Your reference: SSI-10050
Our reference: DOC22/607881

Advice on EIS – State Significant Infrastructure – Wilcannia Weir Replacement (SSI-10050)

Figure 1-4: Key construction features - existing weir site

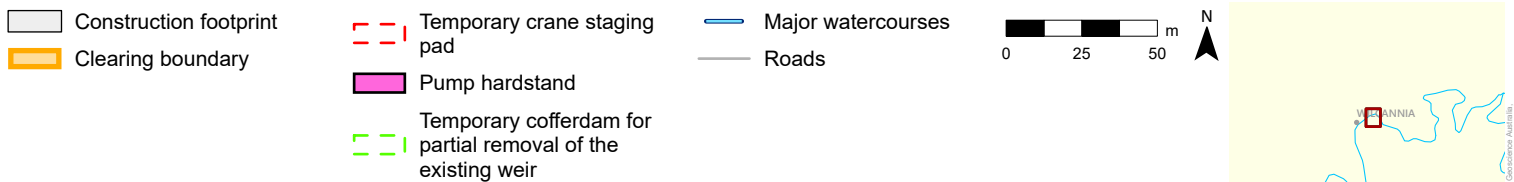
- A plan detailing the extent of the existing weir that will be removed.
- Impacts that the laydown and clearance areas adjacent to the existing weir will have on culturally modified trees and potential subsurface deposit.
